Subject: RE: Planning Consultation on: FP/32/21/PL

Application No: **FP/32/21/PL**

Site Address: Land adjacent to 10 Second Avenue Felpham PO22 7LJ

Description of Works: Two storey, 4 Bed detached dwelling with new access & parking. This site is in CIL Zone 4 & is CIL Liable as new dwelling.

# PROPOSED STREET ELEVATION

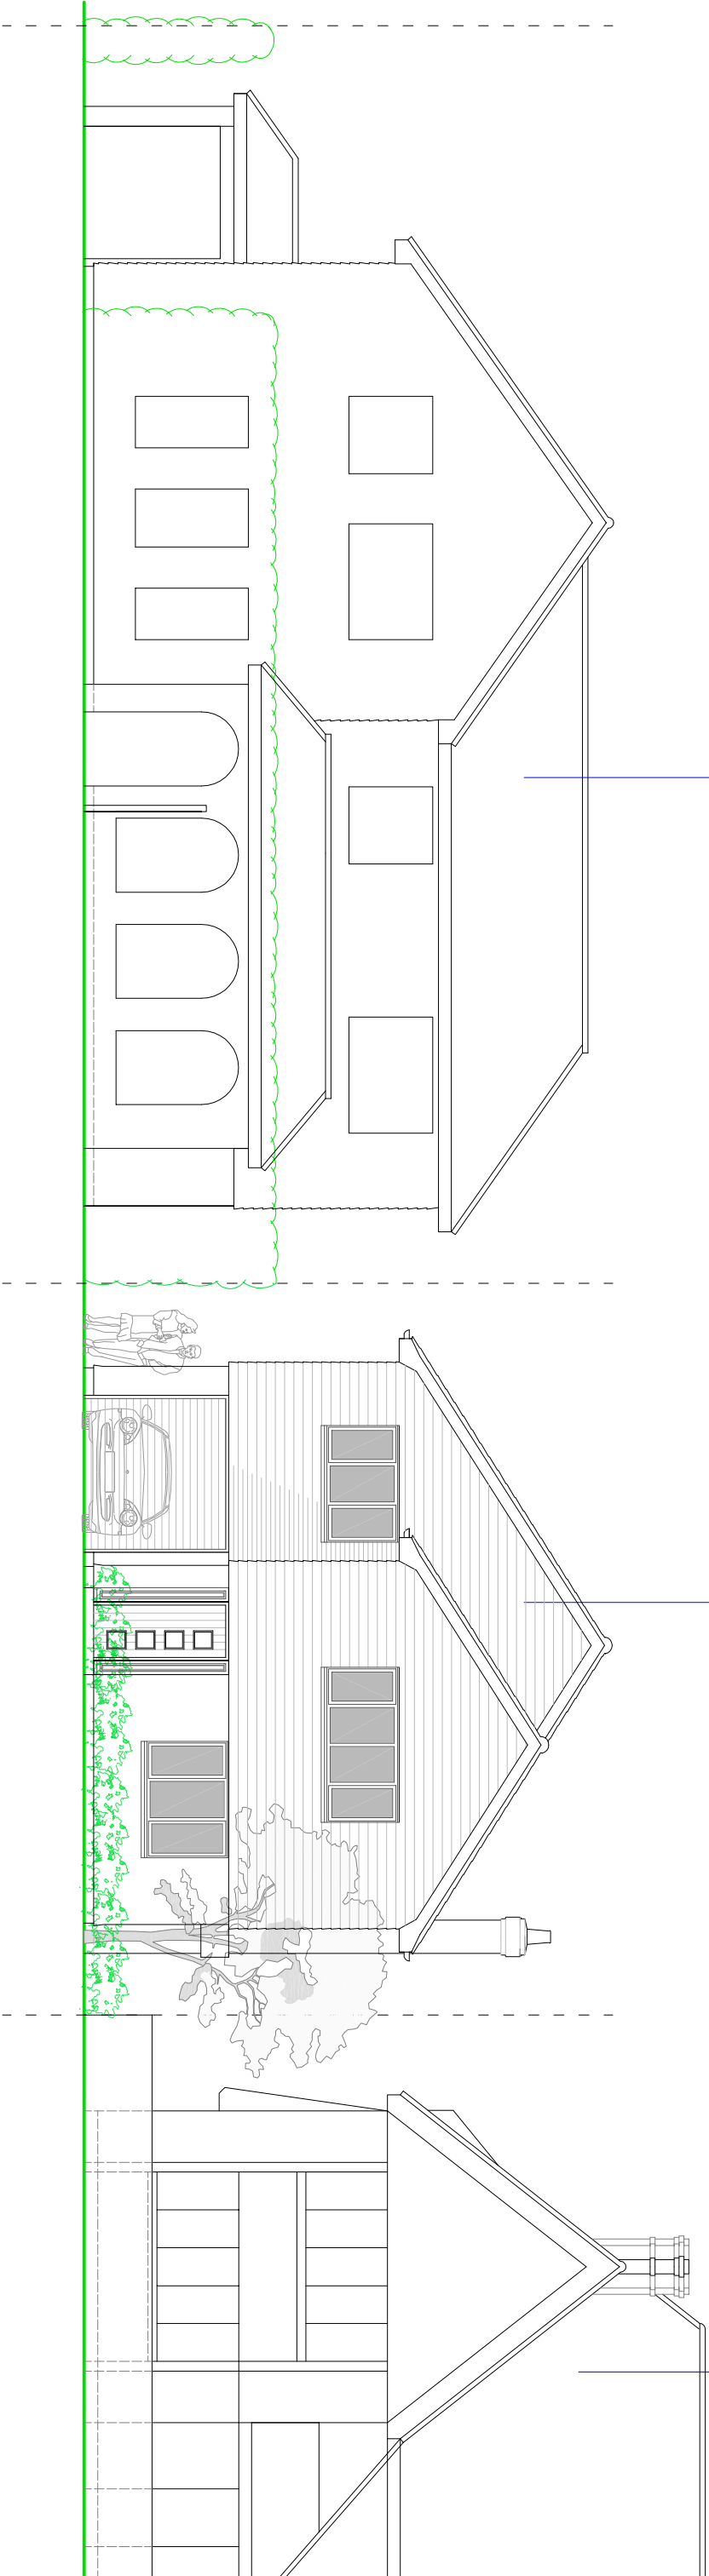
With respect to the proximity of the proposal to the coast, it would be prudent to raise FFLs up slightly from what the proposal would otherwise have. I would suggest that a modest 200mm increase would provide for a sustainable development without unduly affecting the accessibility or the streetscene (e.g. overall height in relation to neighbouring property).

Therefore, no objection in principle but would suggest an advisory re slight raising of floor levels on the basis that whilst the proposal is landward of a robust seawall and timber groyne field (both of which are currently maintained by Arun DC), the implications of Climate Change and sea level rise may increase spray etc. that could be carried over the defences and may pose a flood risk during the lifetime of the development.
